M25 junction 28 improvement scheme

10.12 Report on Proposed Scheme Changes 5-7

Regulation Number	Regulation 5(2)(q)
Planning Inspectorate Scheme Reference	TR010029
Application Document Reference	TR010029/EXAM/10.12
Author:	M25 junction 28 scheme, project team, Highways England

Version	Date	Status of Version
0	21 April 2021	Request for Changes 5-7, Deadline 6

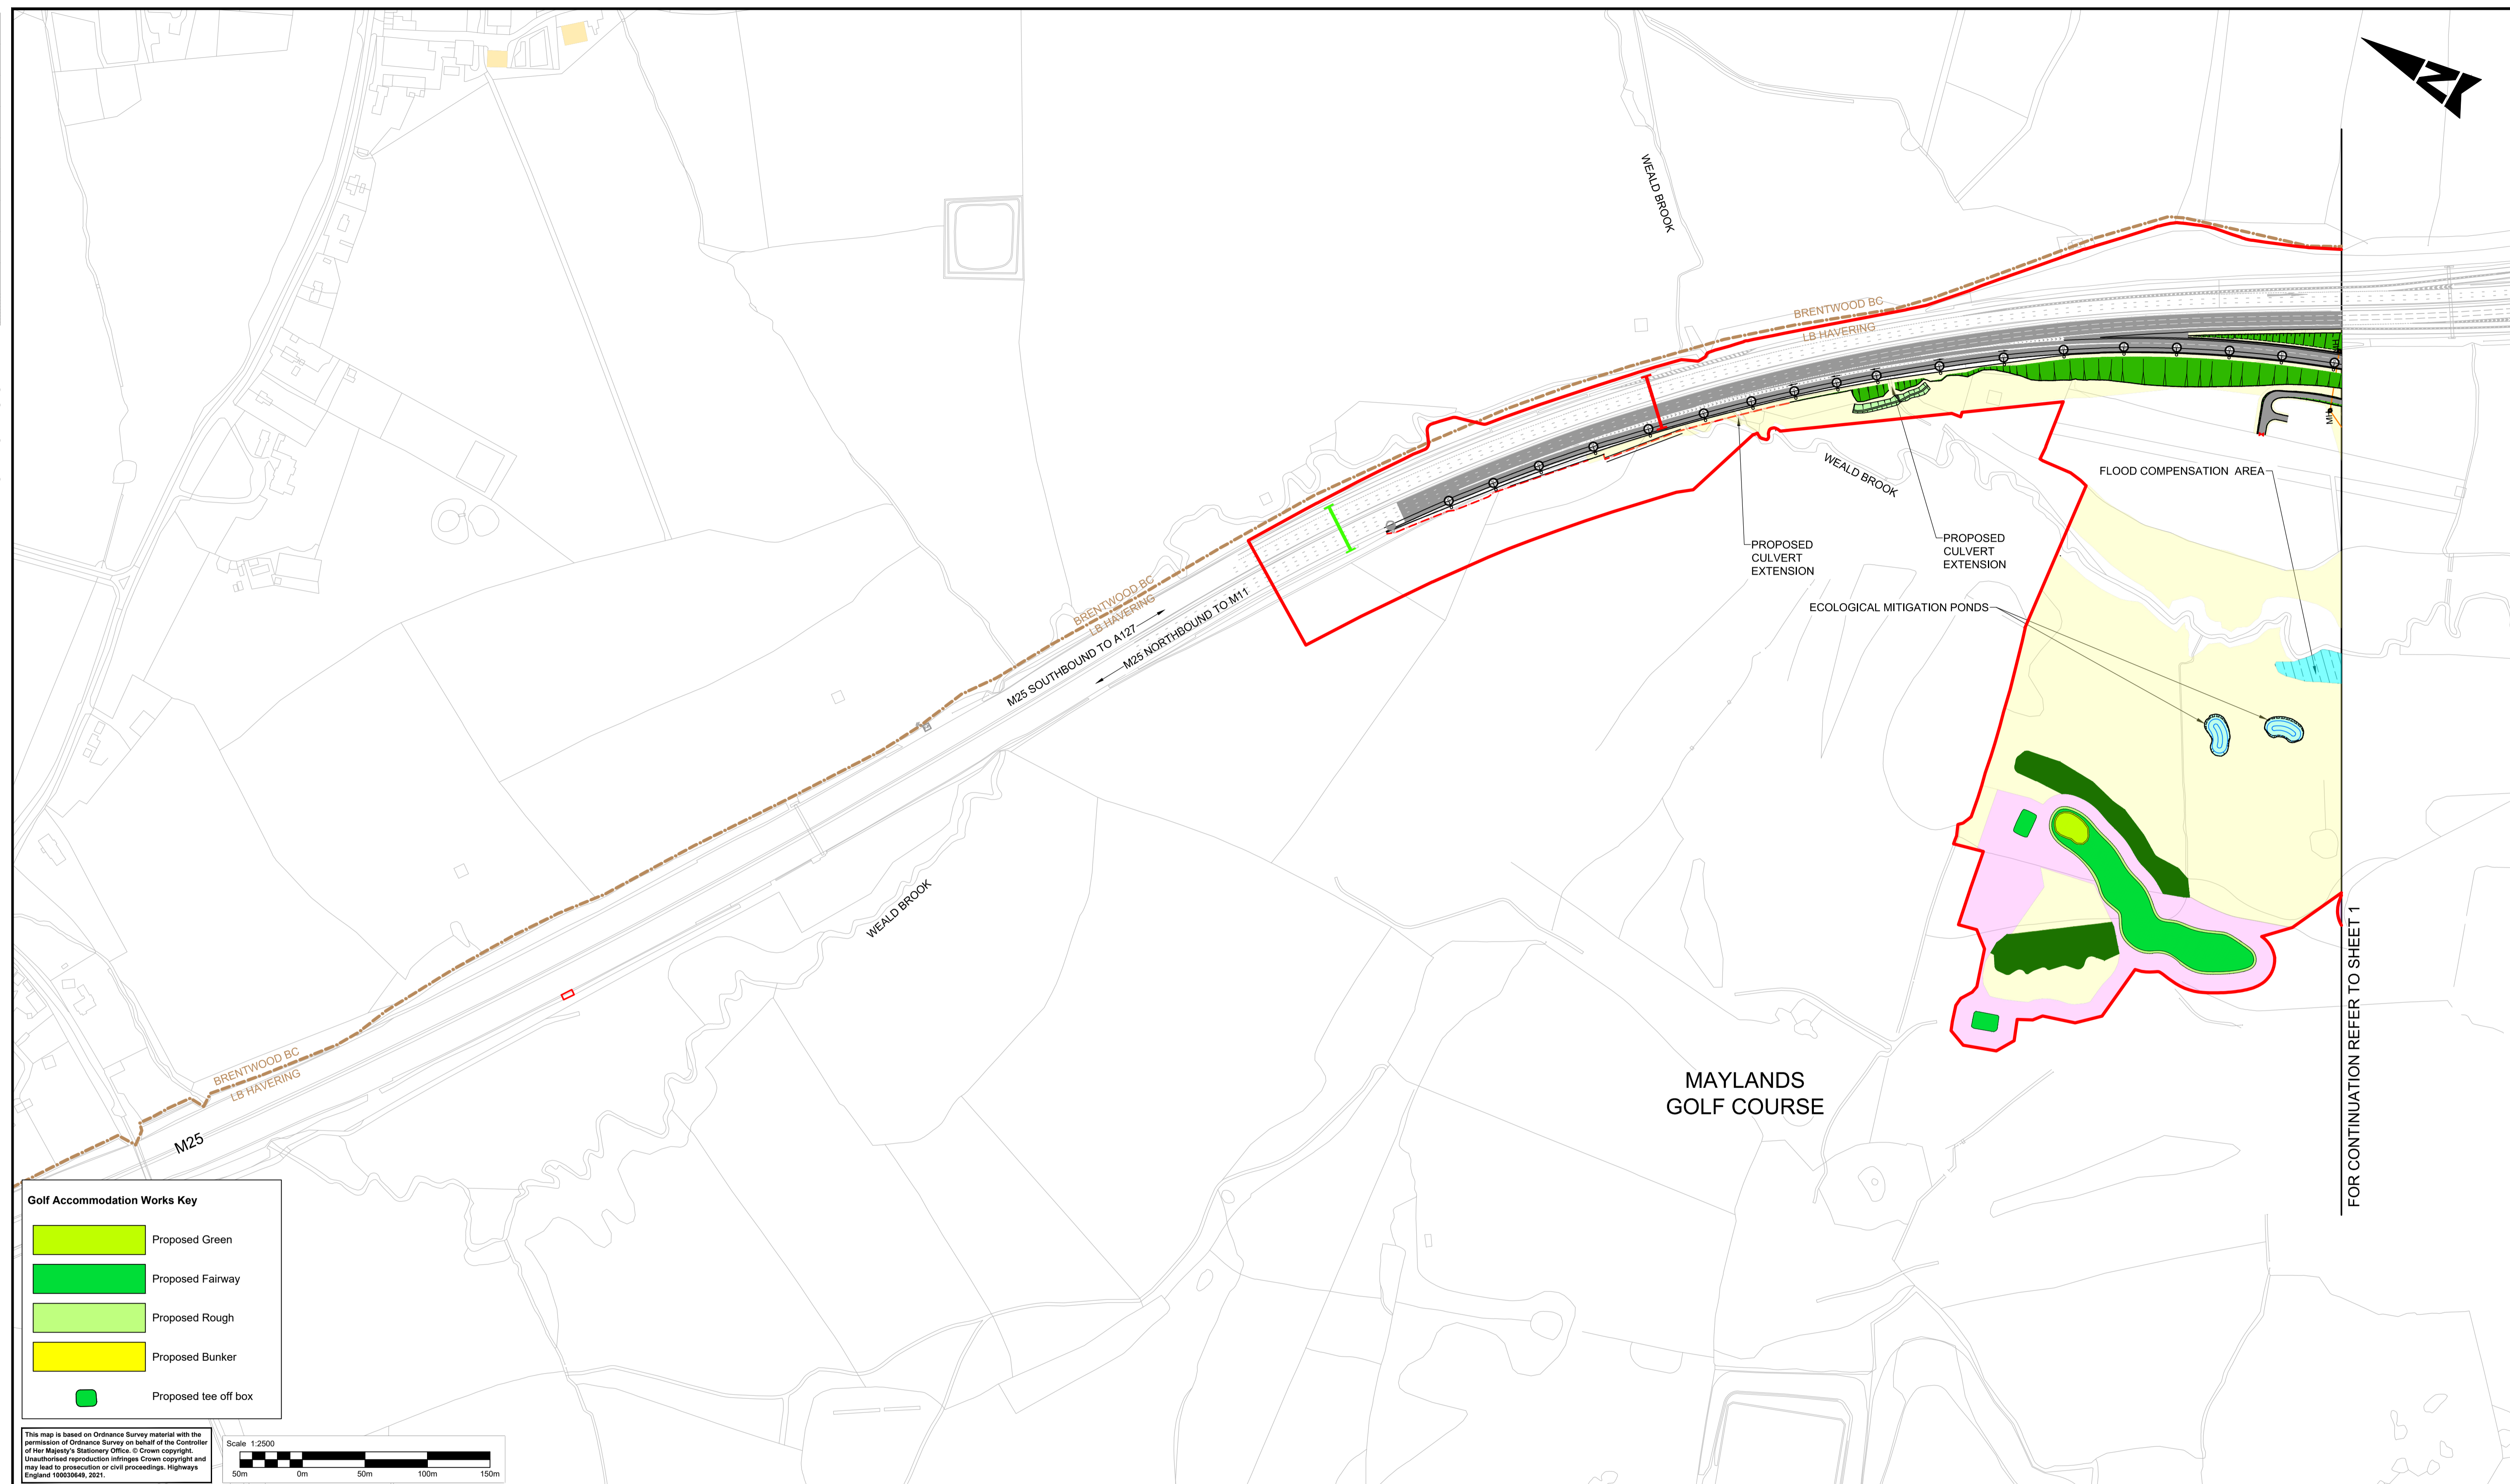
5.4.1 Change 7 would require an extension to the Order limits to those submitted in the Application to cover the areas required for the golf course remodelling works, for associated landscape and ecological works, as well as to facilitate an area required for an associated construction compound. The extension to the Order limits is required to include additional land (28,450m²) for temporary possession. The overall total area of Work No.32 for Change 7 is 54,578m².

**PLAN**  
SCALE 1:200

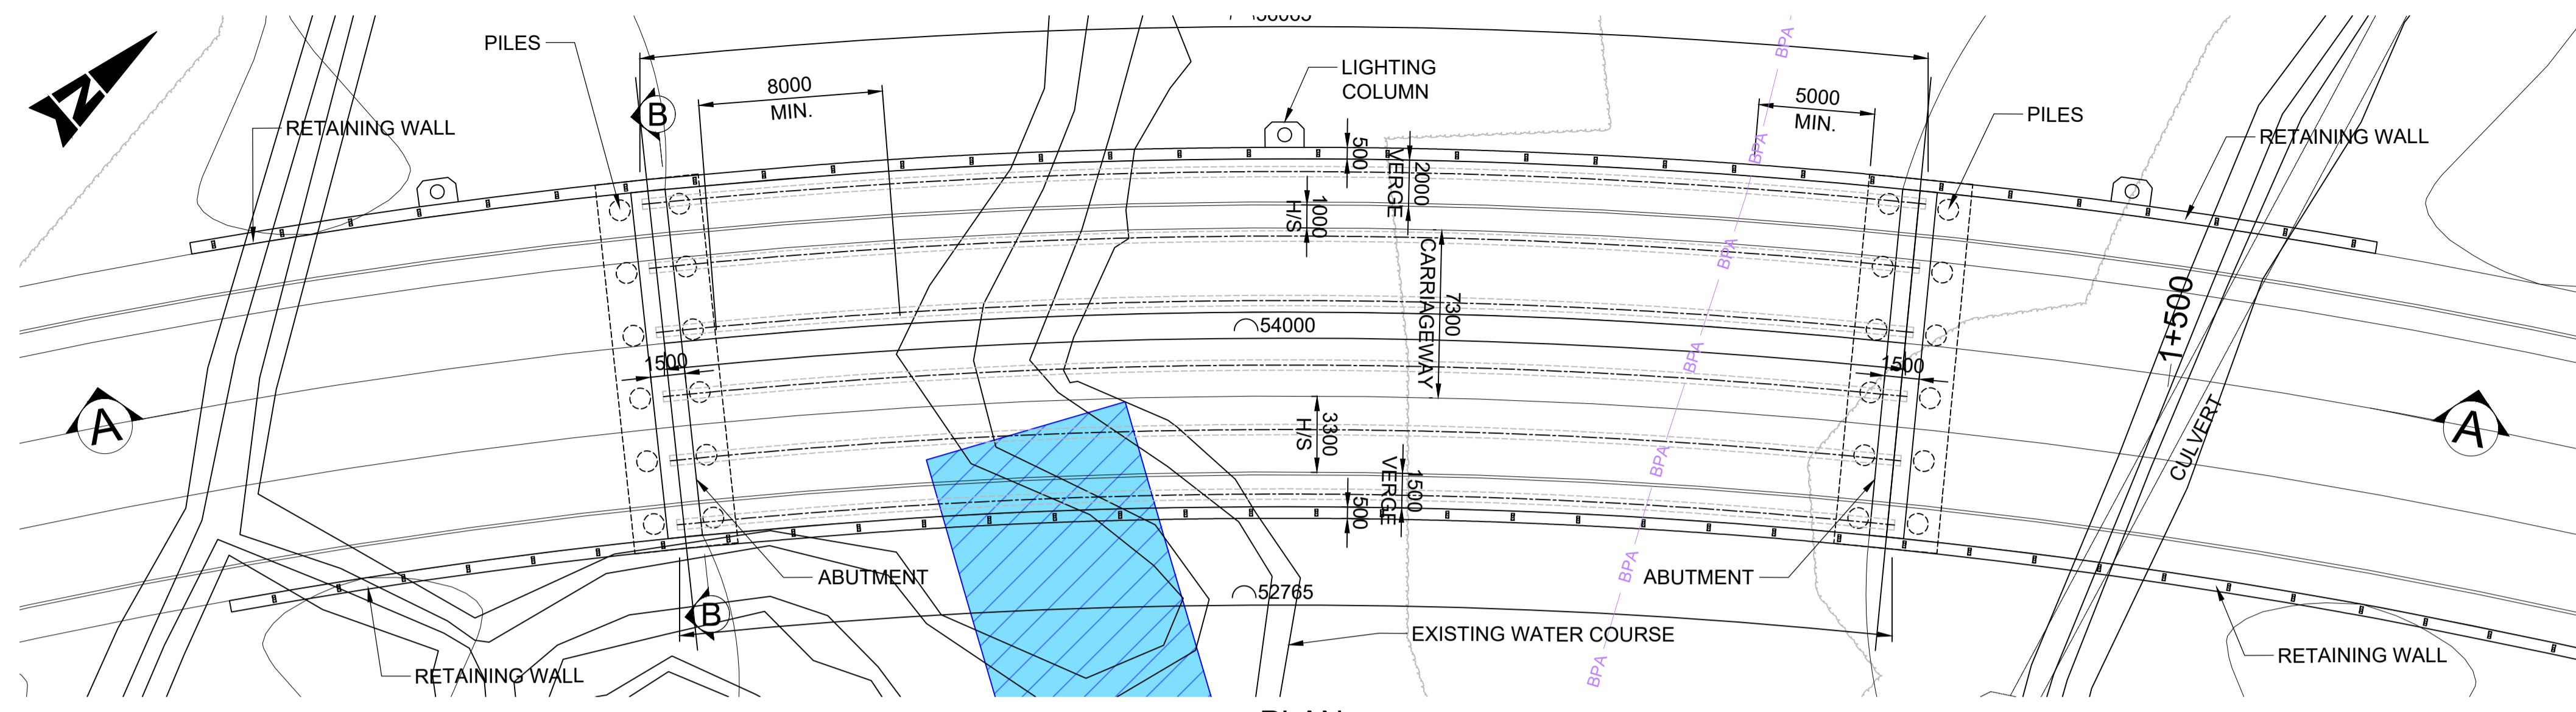
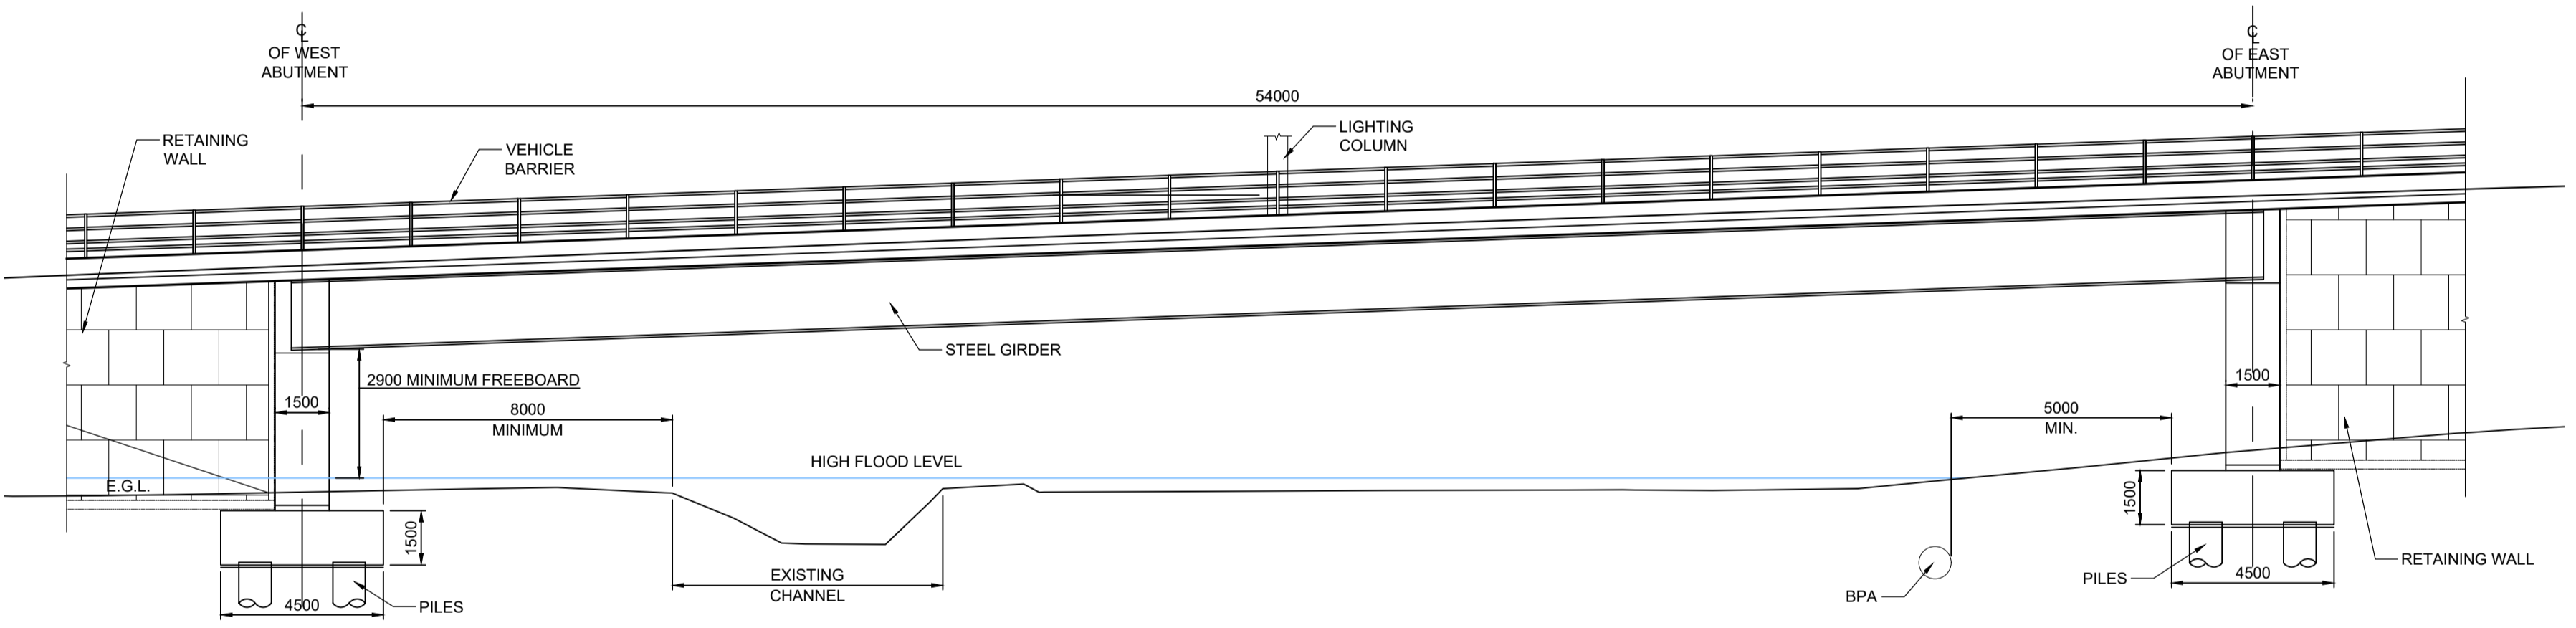
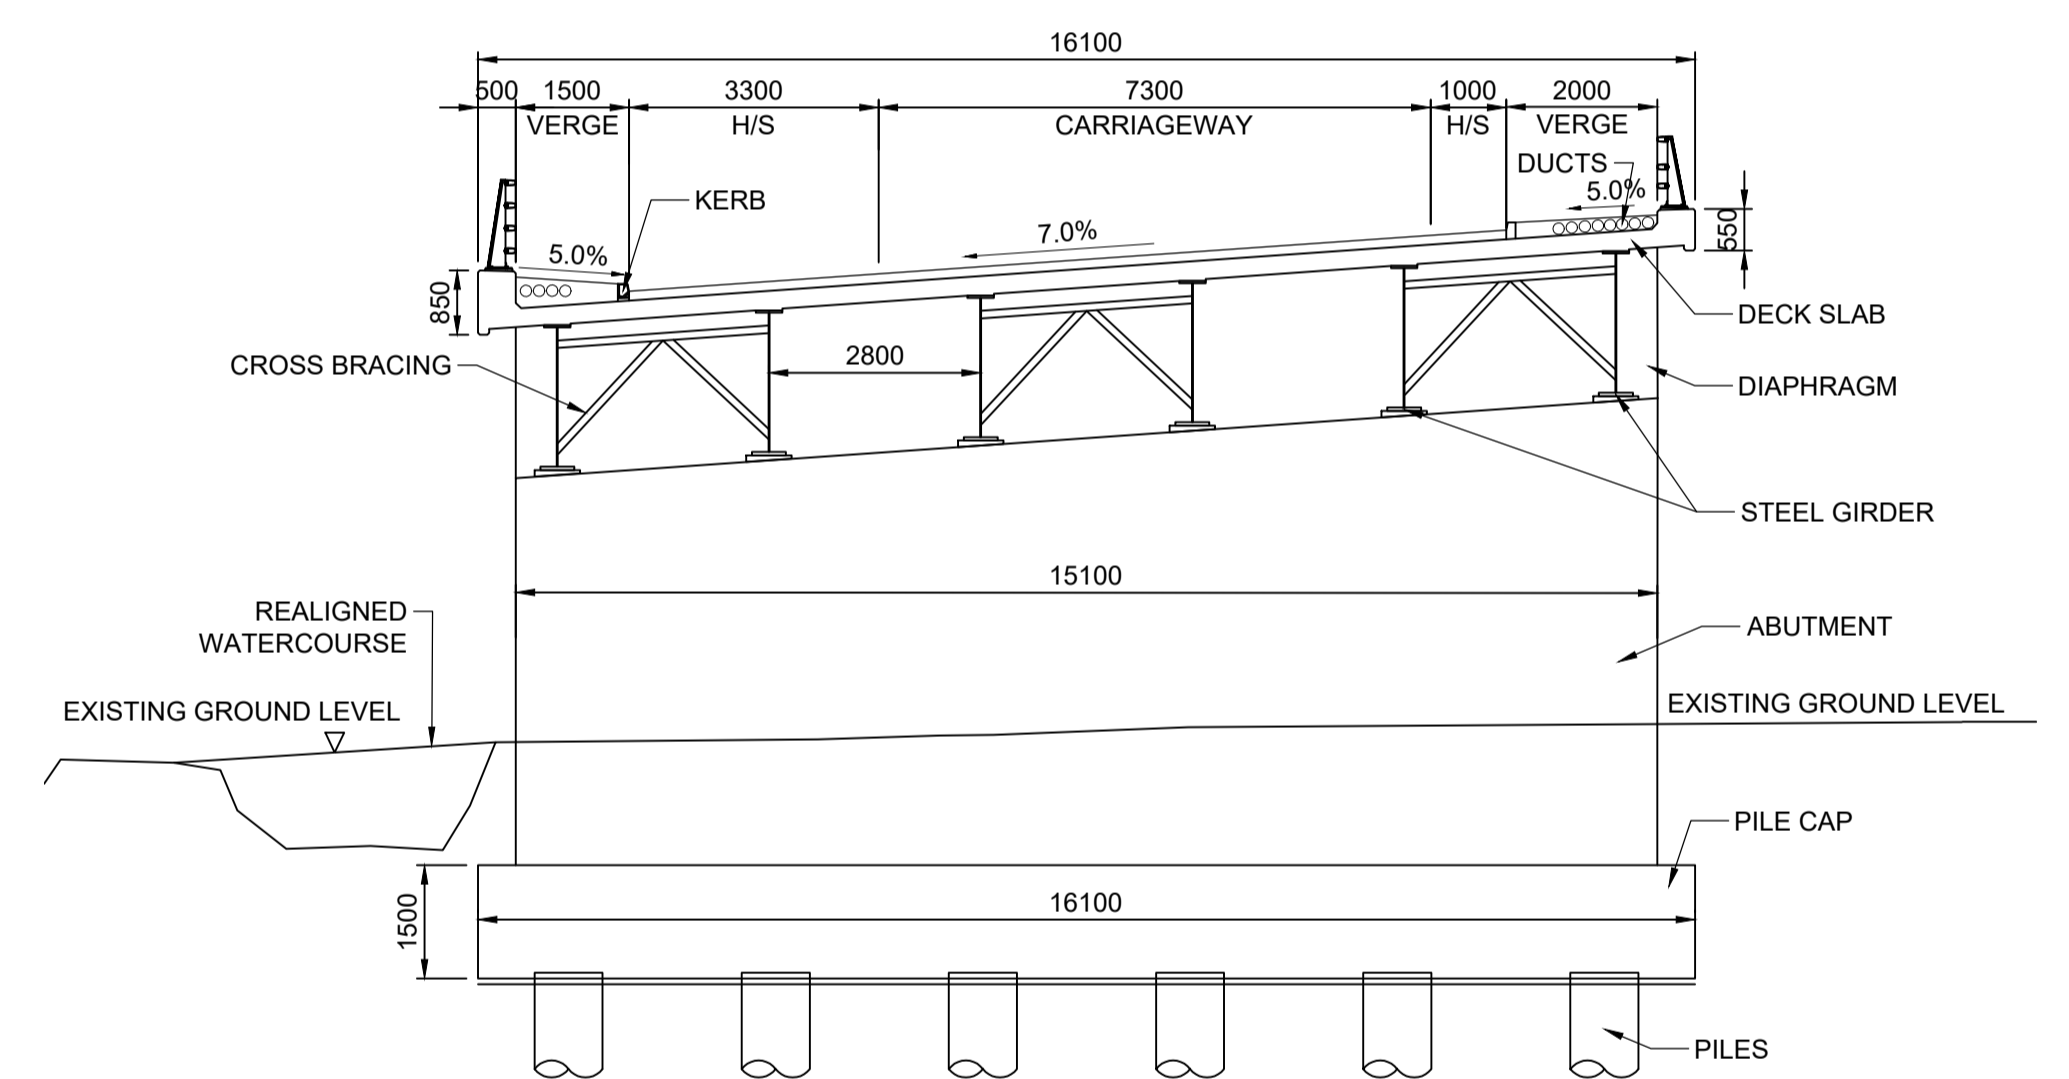
3.2.1 The original design for Duck Wood bridge was a two-span bridge with a central supporting pier which resulted in the need to realign a stretch of the Weald Brook (Work No. 23C). As a result of design development, revisions are proposed to the design of the bridge, including removal of the central supporting pier, meaning that the extent of realignment of the Weald Brook is reduced.
